**KIRKLEES METROPOLITAN COUNCIL
INVESTMENT & REGENERATION SERVICE**

**DELEGATED DECISION TO DETERMINE APPLICATIONS FOR
NON-MATERIAL AMENDMENTS**

Reference No: **2024/NM/92159/E**

Site Address: Land off, Kenmore Drive, Cleckheaton, BD19 3EJ

PROPOSED ROOF PLAN

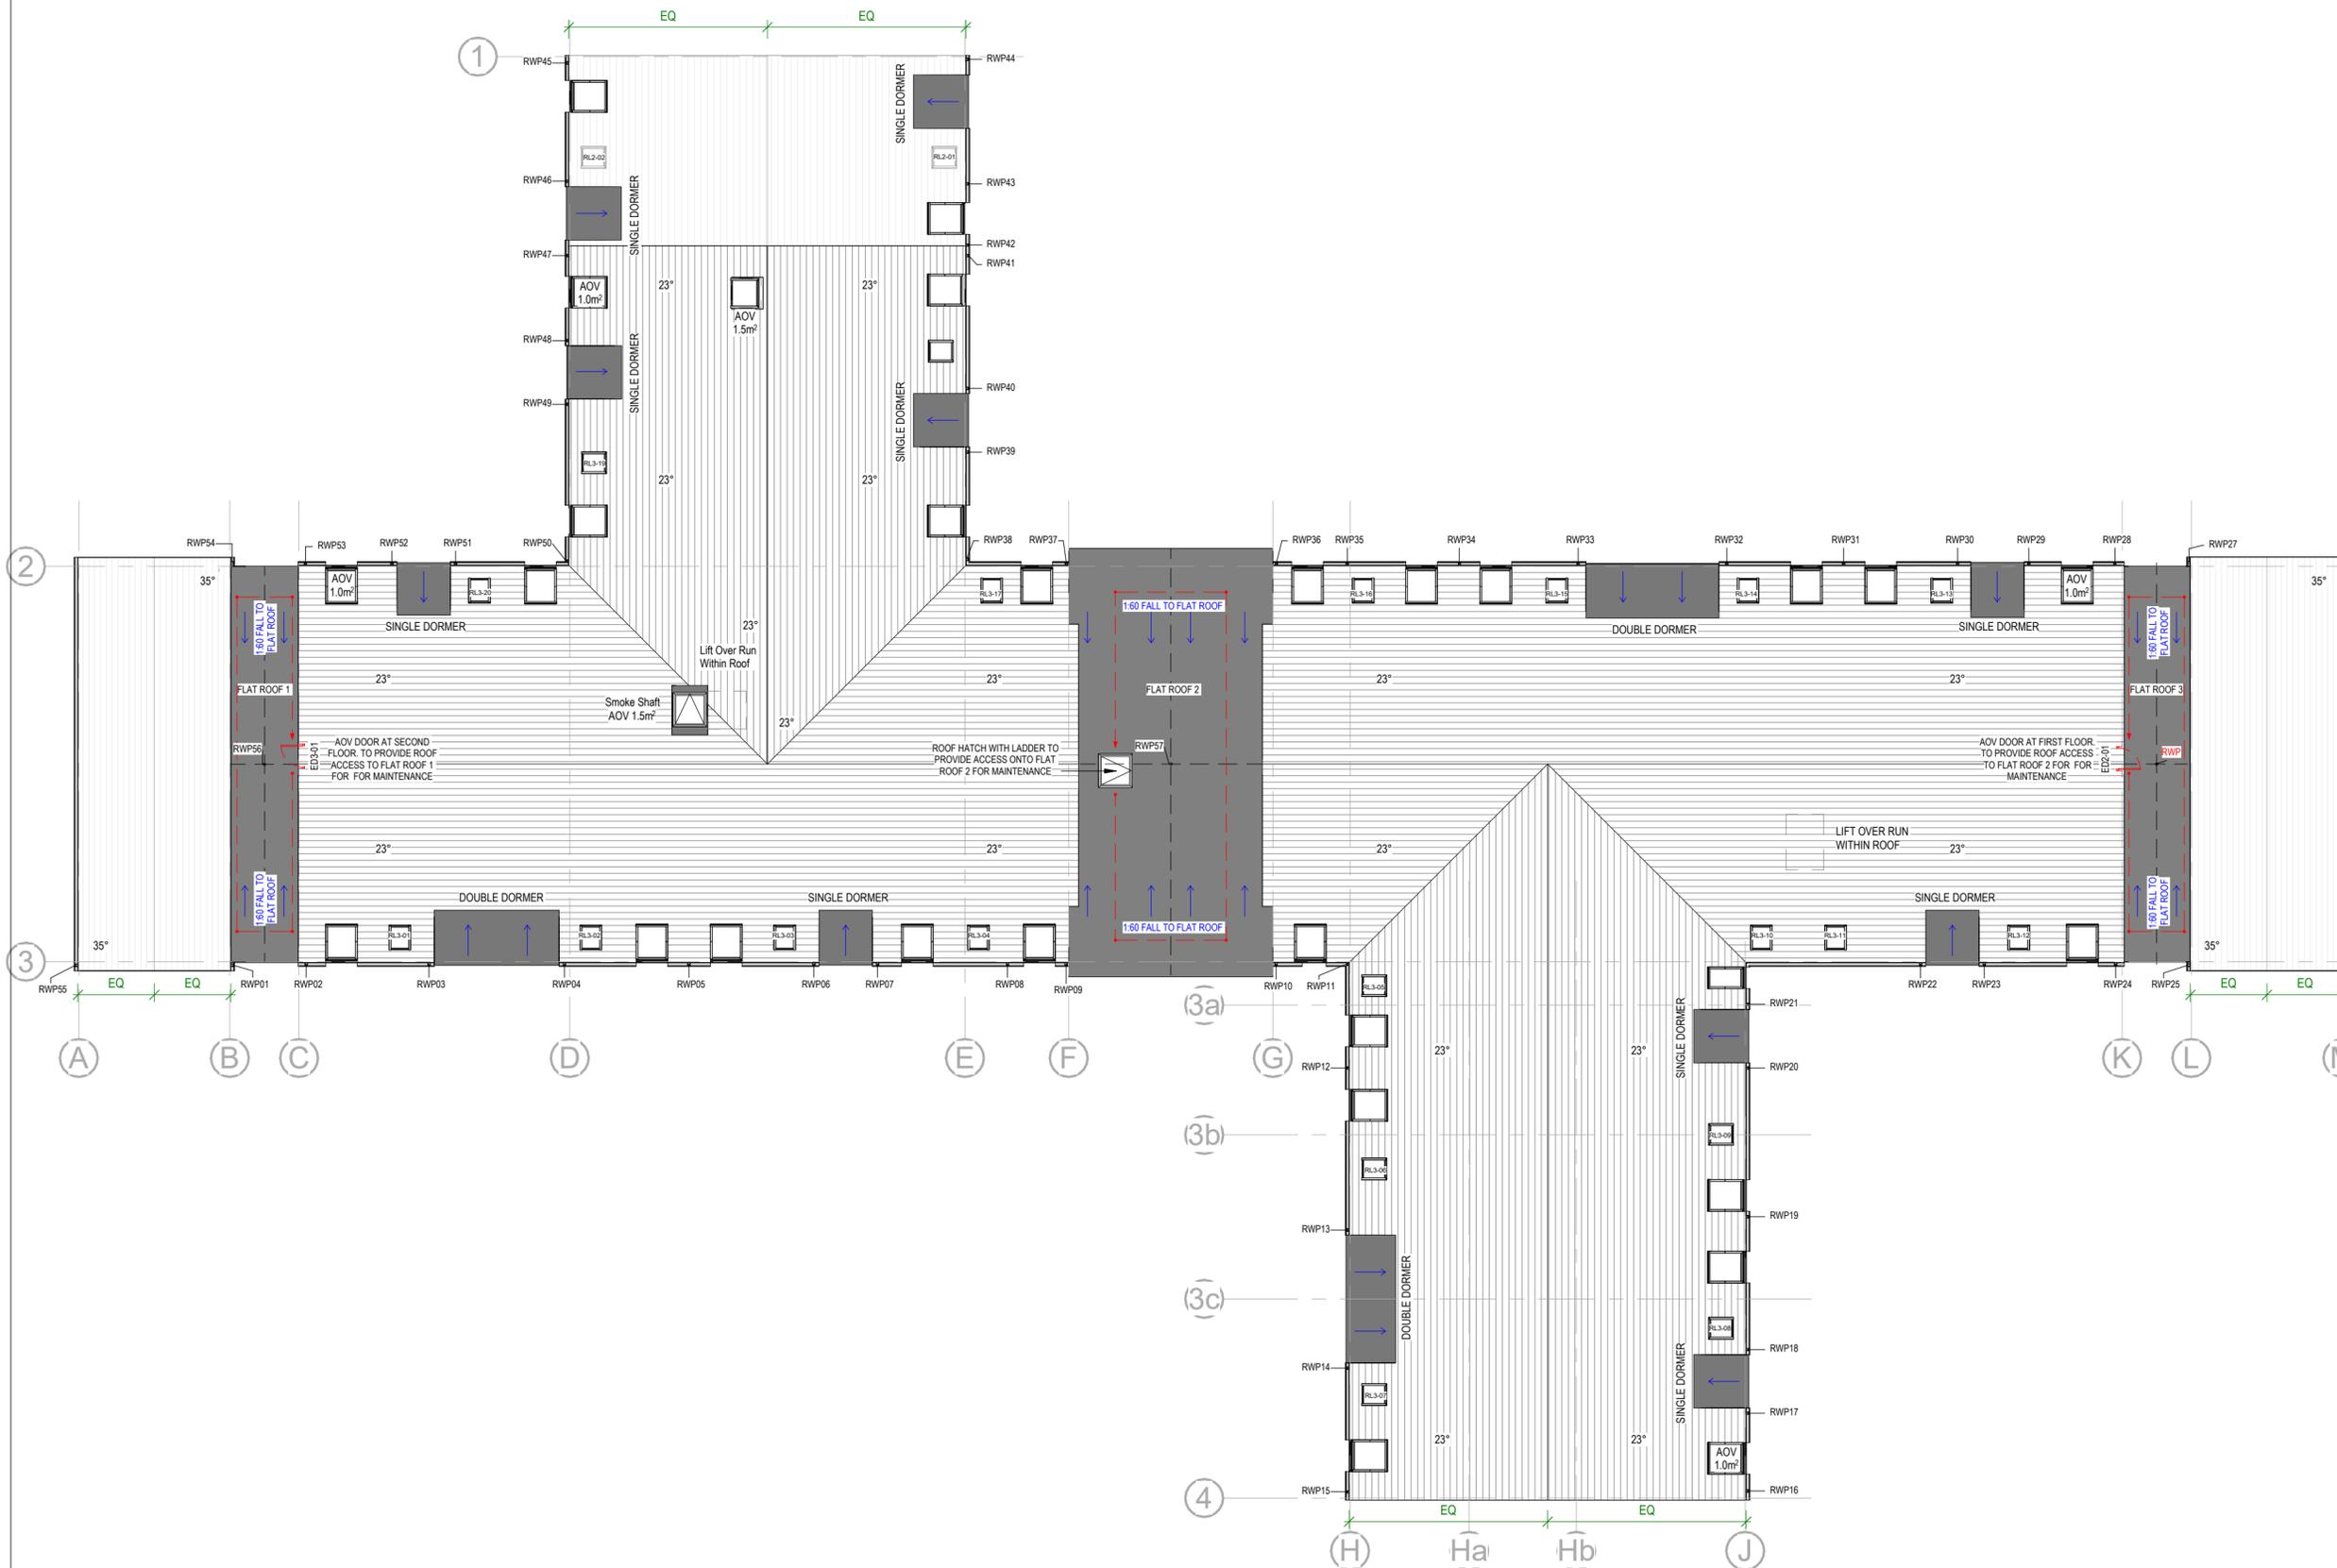
- Omission of internal atrium including glazing on the roof slope (west and east elevation)
- Increase in height of flat roofs to allow for larger service voids for accommodation of M&E equipment. Flat roofs 1&3 have raised by approximately 500mm and the middle flat roof 2 has raised by approximately 300mm

- Automatic opening vent details added (west elevation) and projection through roof (north elevation, west elevation)
- Change of dormers to combination rooflight (south elevation, north elevation)

- Combination rooflight revised to single pane (all elevations)
- Recesses for rain water pipe omitted (all elevations)
- Ground floor buggy store single door change to double door (south elevation)
